KITTITAS COUNTY

MEMORANDUM

TO: All Staff
FROM: Public Works Plan Review Team
DATE: July 8, 2026- SURVEY JULY 20, 2026
SUBJECT: BL-26-00009 Helveston

RECORD OF SURVEY
PART OF BLOCK G, SUNLIGHT WATERS II
& OF THE SOUTHEAST QUARTER OF SECTION 24,
TOWNSHIP 19 NORTH, RANGE 16 EAST, W.M.

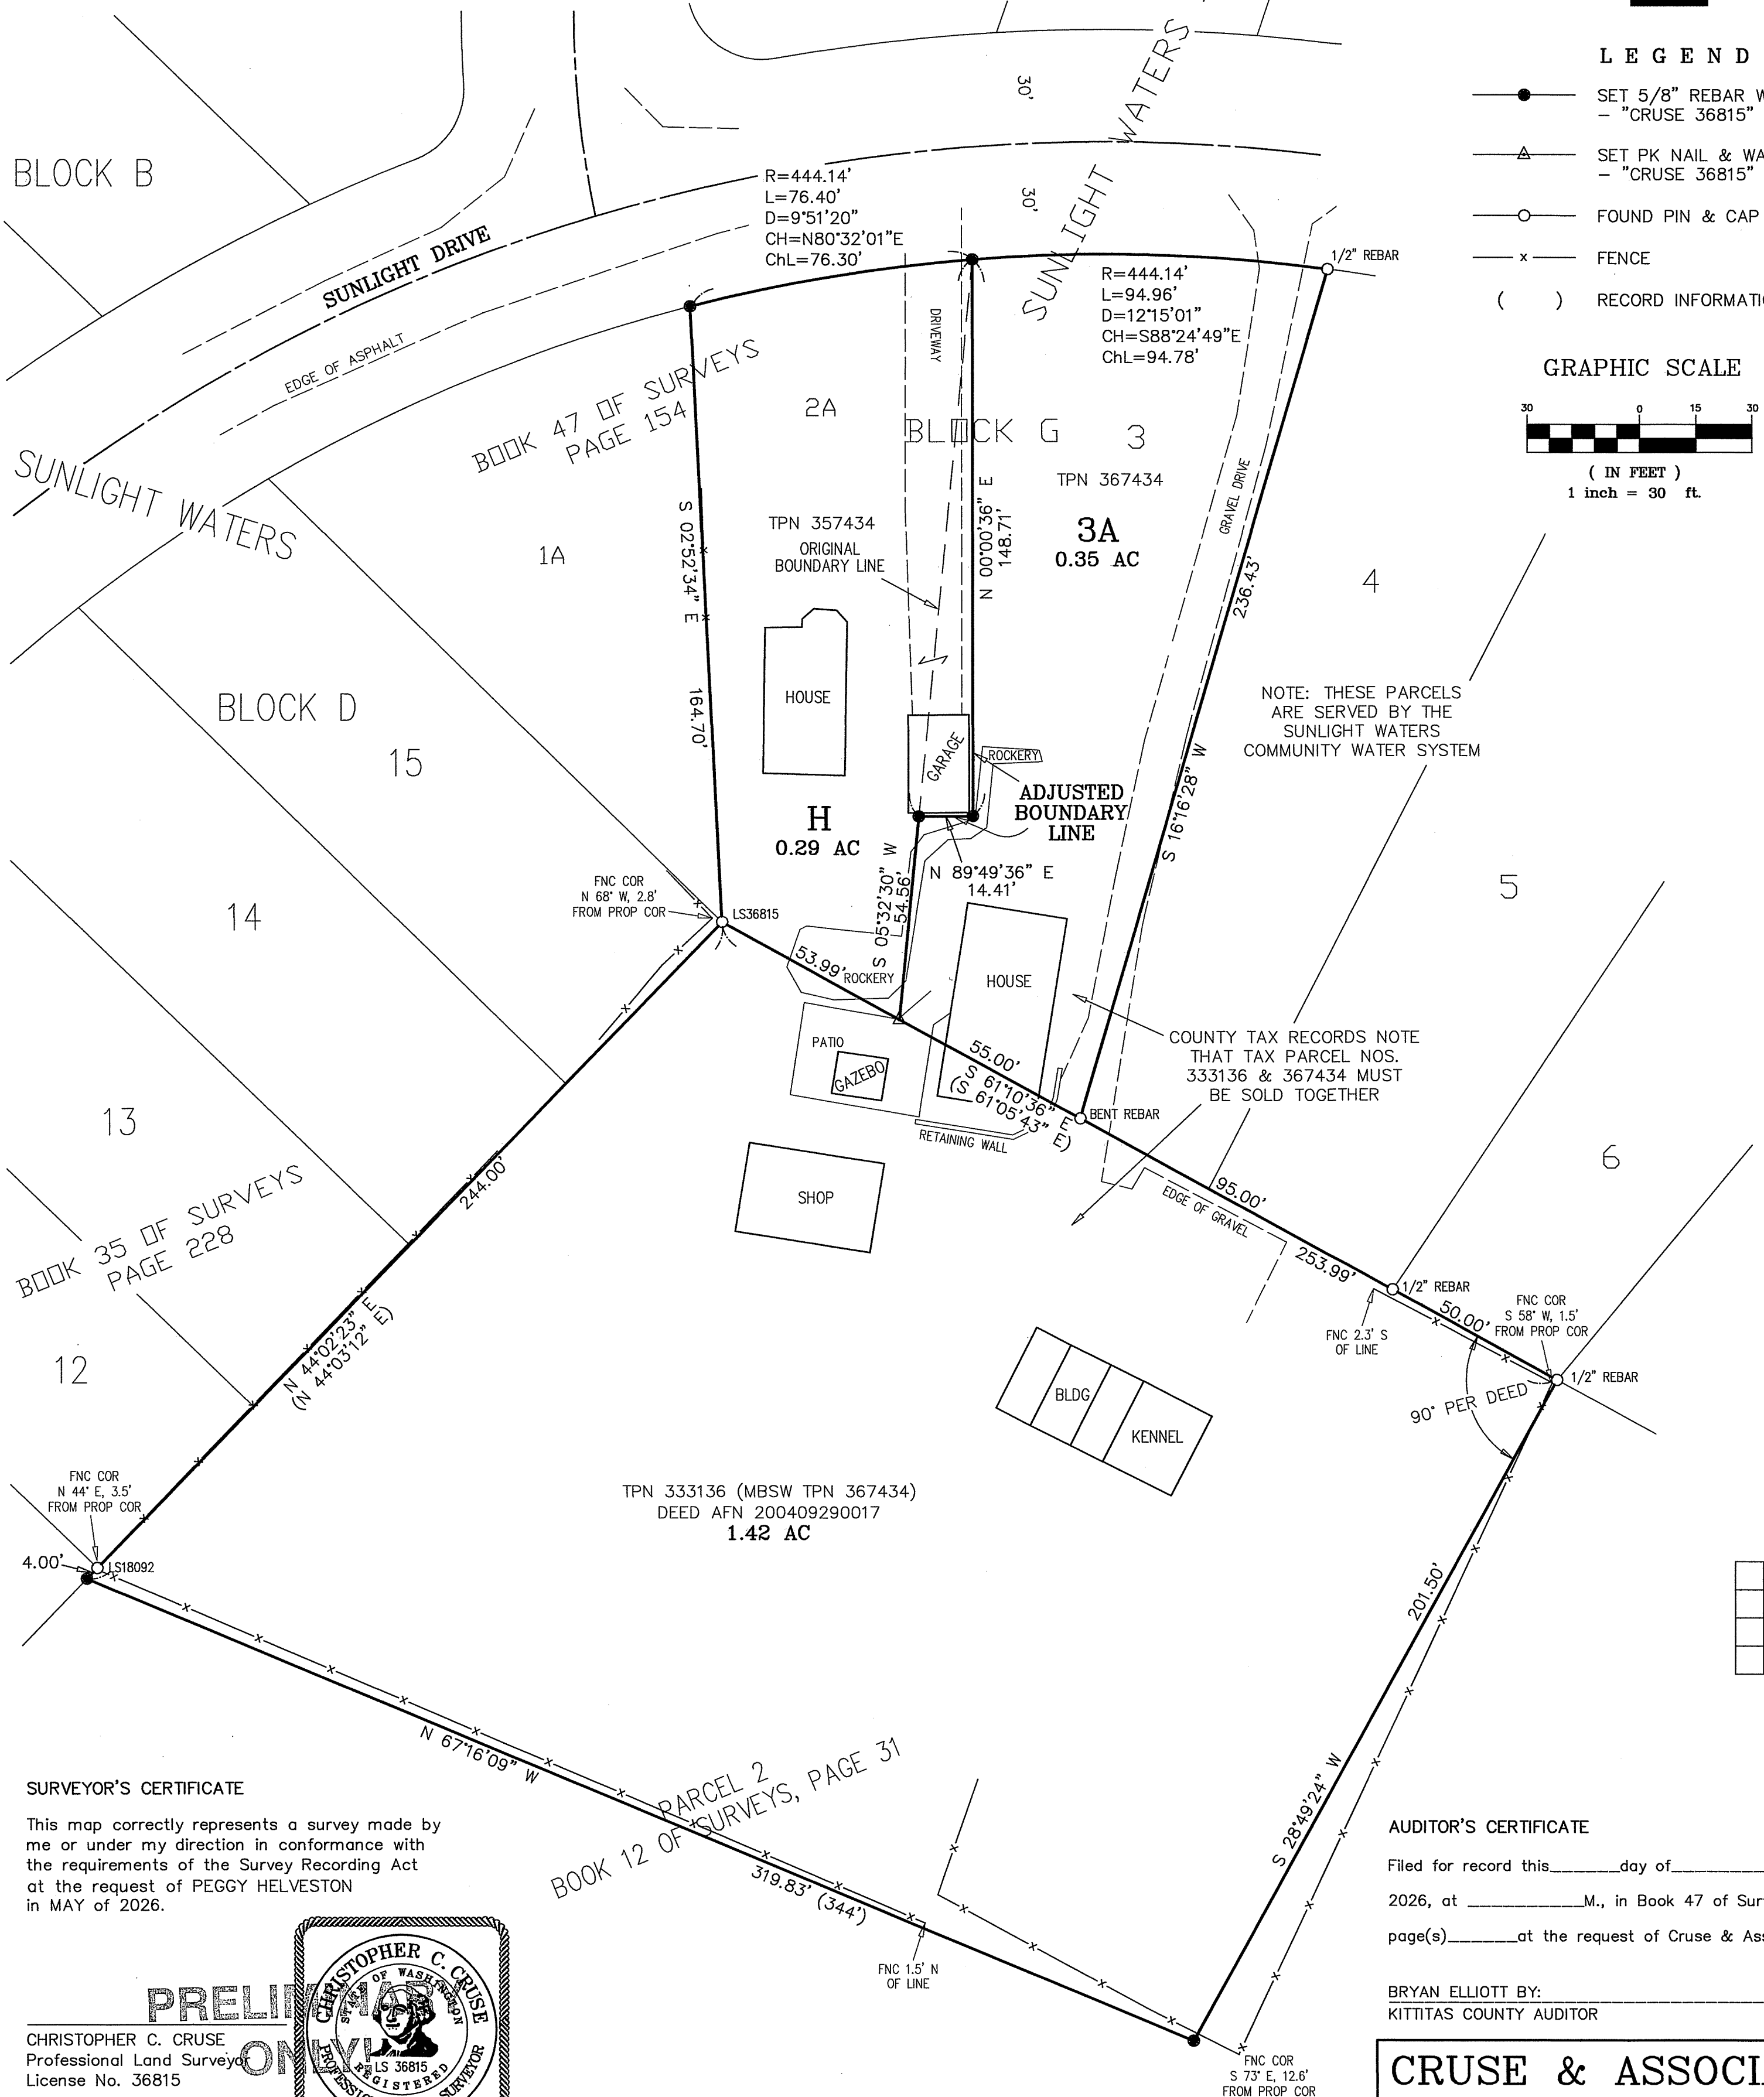
SURVEY	As the application does not contain a survey map, comments are herein reserved until final submittal. (KH) UPDATE 07/21/2026 1. Please identify offset distance between adjusted boundary and existing face of garage. 2. If the garage eaves present an aerial trespass, please note on the face of the survey. 3. Please identify Sunlight Drive as being a country right of way. OF NOTE (not a requirement for approval) 4. The building outline for the house on Lot H does not appear to match aerial images from 2022, particularly along the south extents. The planner of record has deemed that correcting this is not a requirement. 5. There appears to be a structure located North of the House on Lot H per

aerial images, which may actually encroach onto the 10' setback. The planner of record has deemed that correcting this is not a requirement. (JT) UPDATE 07/30/2026 All prior comments have been addressed on the updated submittal. (JT)
TRANSPORTATION CONCURRENCY	No Comment. (RC)
FLOOD	No comments. (SC)
WATER MITIGATION/ METERING	No comments. (SC)
AIRPORT	Project is not located withing Airport Overlay. (RC)
